From: Jennifer Pollitt [REDACTED]
Sent: 15 February 2022 11:21
To: Planning.Responses <Planning.Responses@arun.gov.uk>
Subject: RE: Planning Consultation on: LU/417/21/OUT

Application No: LU/417/21/OUT

Site Address: Land north of Toddington Lane (adjacent to Lyminster Bypass) Hampton Park
Littlehampton BN17 7PP

Description of Works: Outline application with some matters reserved (except access) for the erection of up to 71 No dwellings.

Figure 4. Proposed Layout - Site B

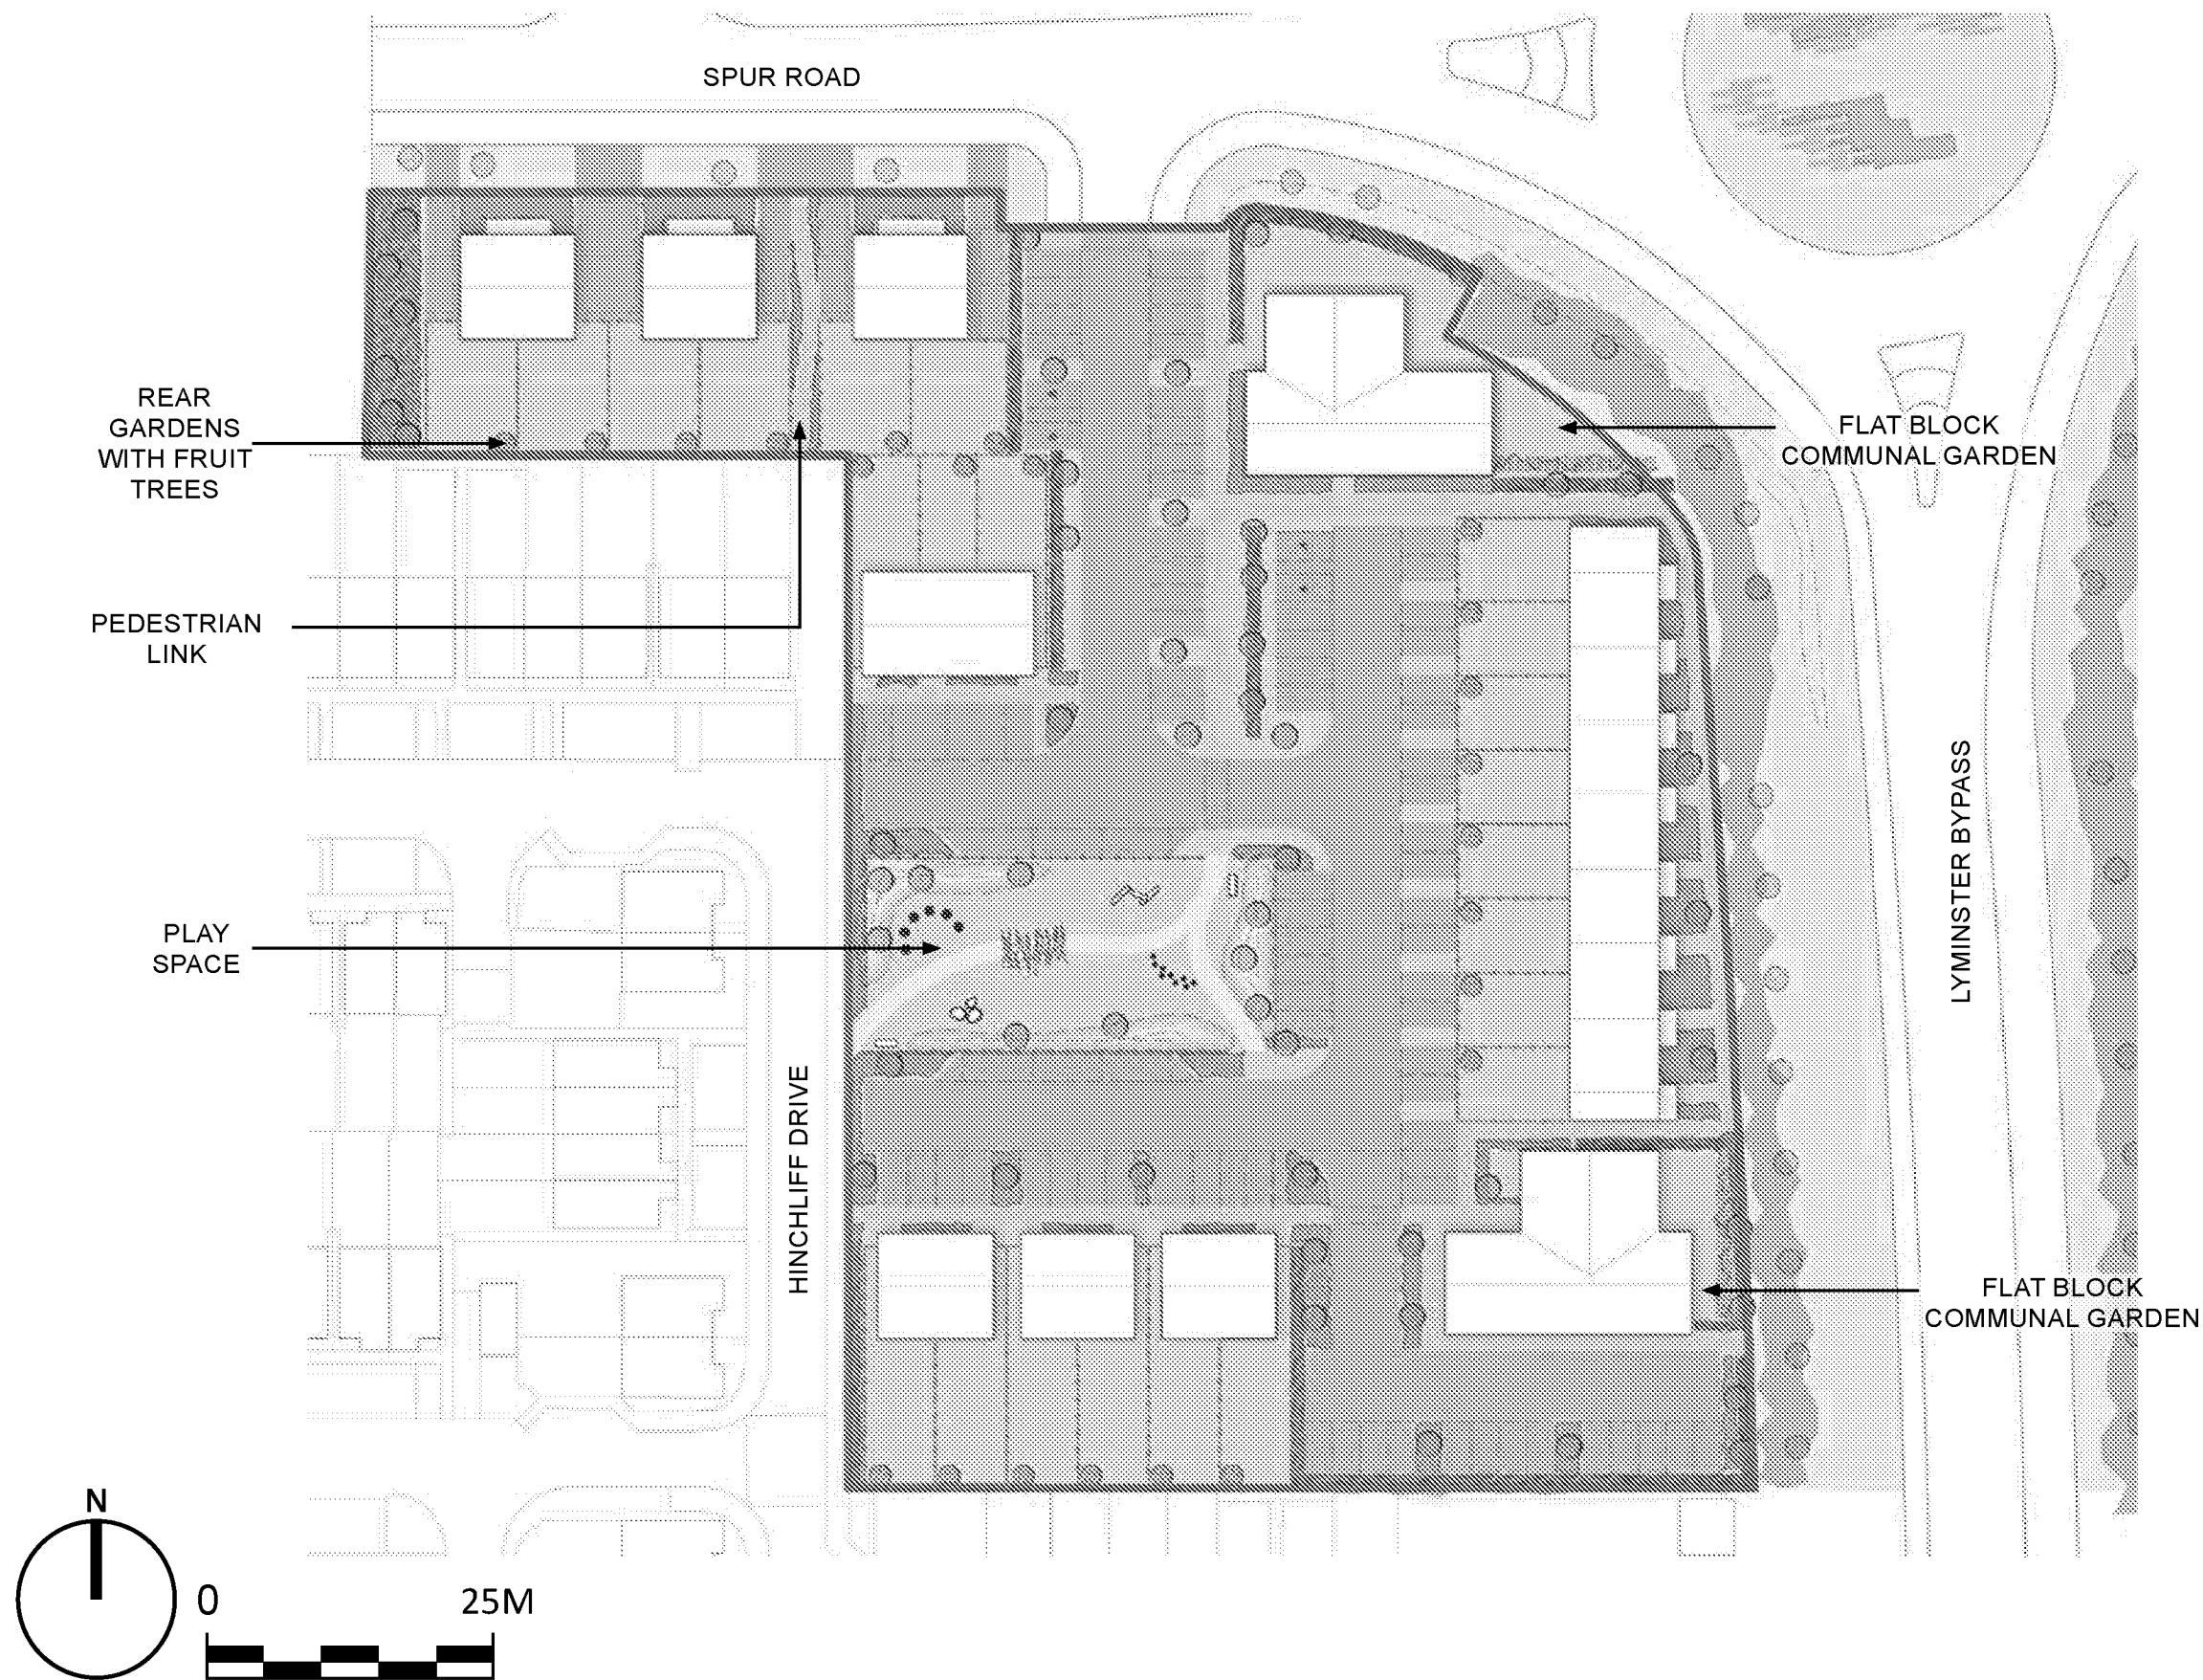
As per the Environmental Impact Assessment (Dec 2021) the trees with roosting potential and hedgerows/boundary vegetation on site will need to be retained. This will include having a buffer strip around the trees and hedgerows (5m) and during construction fencing should be used to ensure this area is undisturbed. Any gaps should also be filled in using native hedge species to improve connectivity for commuting and foraging bats. Conditions should be used to ensure this.

The marginal vegetation to the north and north-west should be retained and protected as recommended above under the 'Bats' section. This will ensure dormice are undisturbed by the proposals.
